# 118 Congress Street

## Bike Racks

### Parking Garage – Grit Separator

10 PRECAST CONCRETE OIL/GRIT SEPARATOR DETAILS

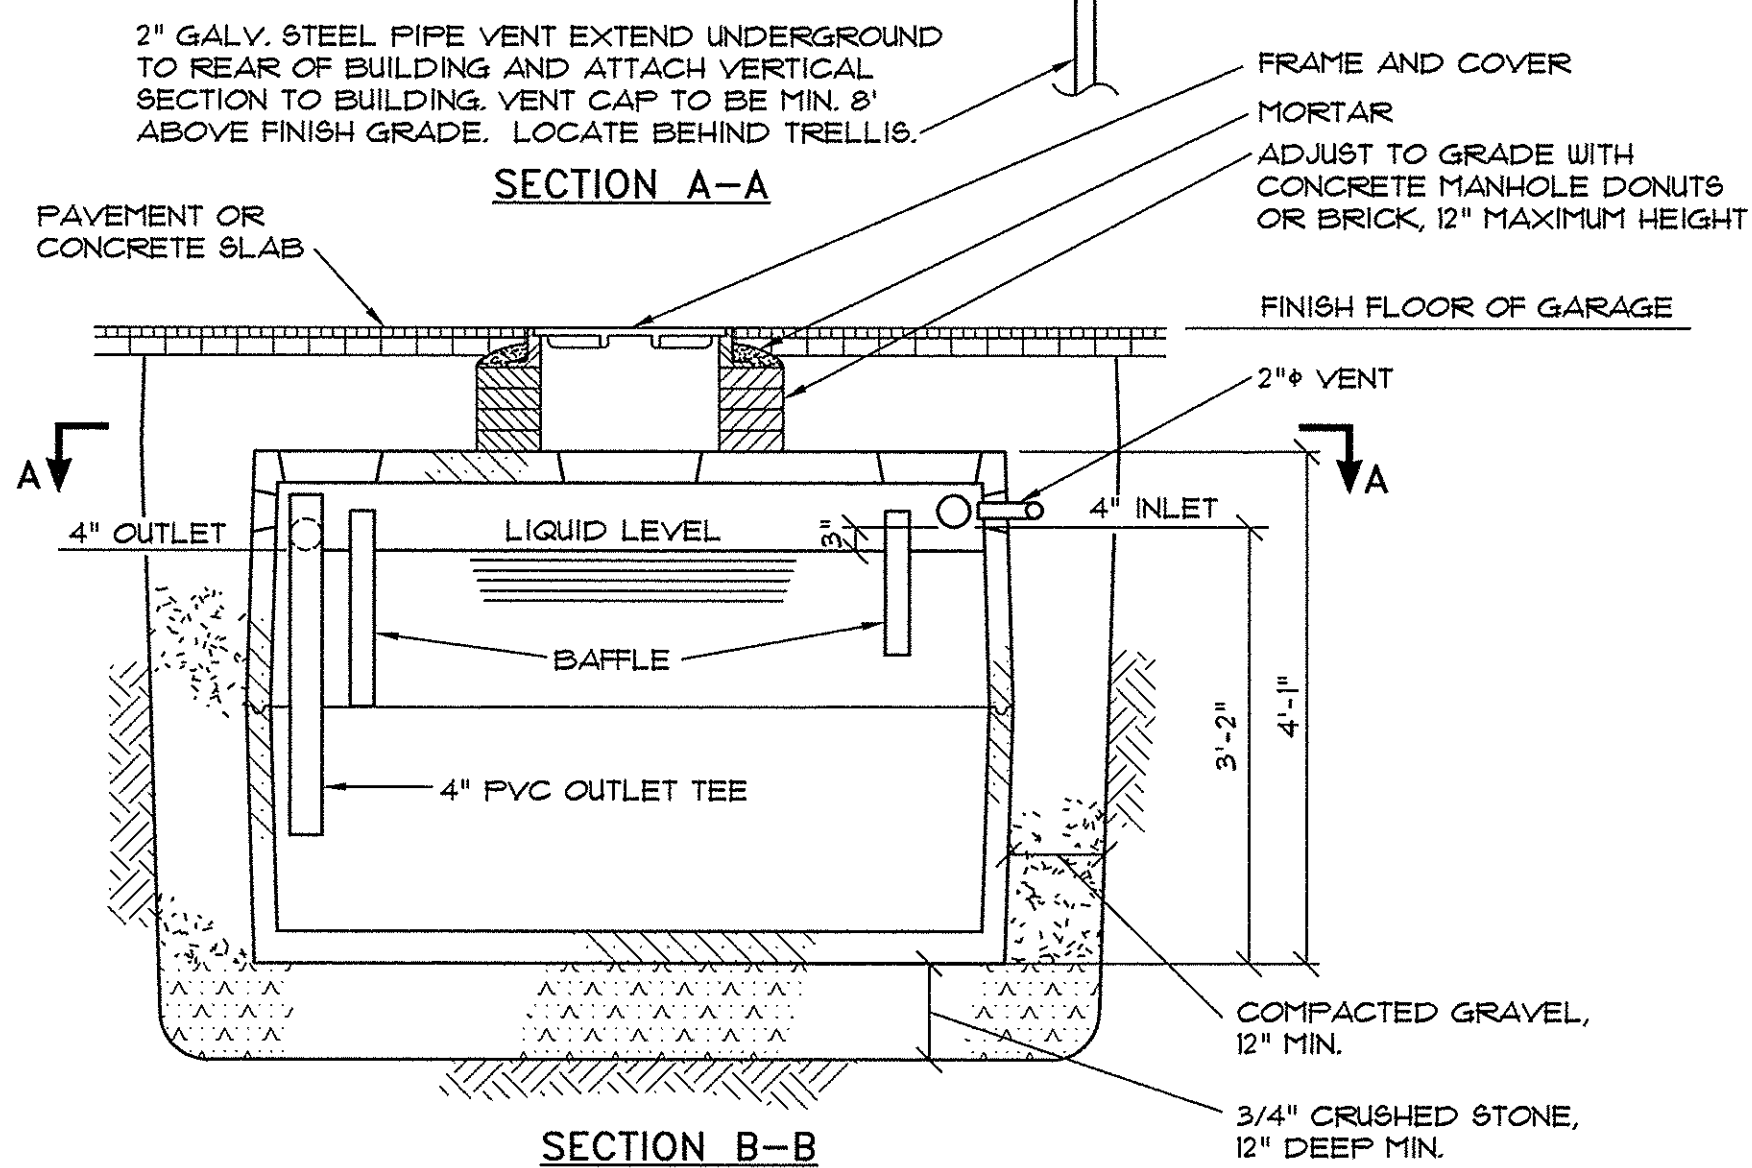
1. The plans for 118 Congress Street included a oil/grit separator in the structured parking area. The construction detail is inserted and it was shown in the floor of the garage on the site plan.

The applicant has submitted the plumbing contractor's analysis that grease/grit separators are not required under the State plumbing code (attached)

During review of covered parking structures, the City of Portland Department of Public Services has consistently required Applicants to provide a structure designed to remove oil and grit from the floor drain system prior to connection into the City's Combined or

Sanitary Sewer System. This is typically a stand-alone structure designed with a sump and a down-turned outlet with oil/floatable storage capacity in the configuration shown on the 118 Munjoy Hill Plans (sheets C1.4 & C1.7), dated 3/27/2014. Although there is no specific code reference that I can point to for this requirement for parking garage areas, the City never allows runoff from a paved/traveled area to enter their system without some means of grit/sediment removal. Specifically the City of Portland Technical Manual requires 3' deep sumps on all catch basin structures, along with a Casco Trap or Snout on the outlet:

In summary, in a typical parking garage scenario, floor drains can be designed to flow through an oil and grit separator or can be collected in City of Portland Standard catch basins with 3' deep sumps and a trap on the outlet. My understanding is that neither of these items have been installed at the 118 Munjoy garage.

- 3. Staff Recommendation:** The staff offered the option of the catch basin described by David above that could be installed inside the garage or outside. If it is outside in the driveway apron (within the street right-of-way), then a license or agreement that the condominium association would be responsible for all maintenance and replacement would be required. The applicant's engineer has indicated that there is insufficient space in the driveway apron due to underground utilities. While the floor drains do have baskets for collection of debris, the units do not handle oil and need frequent cleaning. DPS felt those units were not adequate. DPS is requesting an alternative that more effectively addresses grit, oil and floatables.
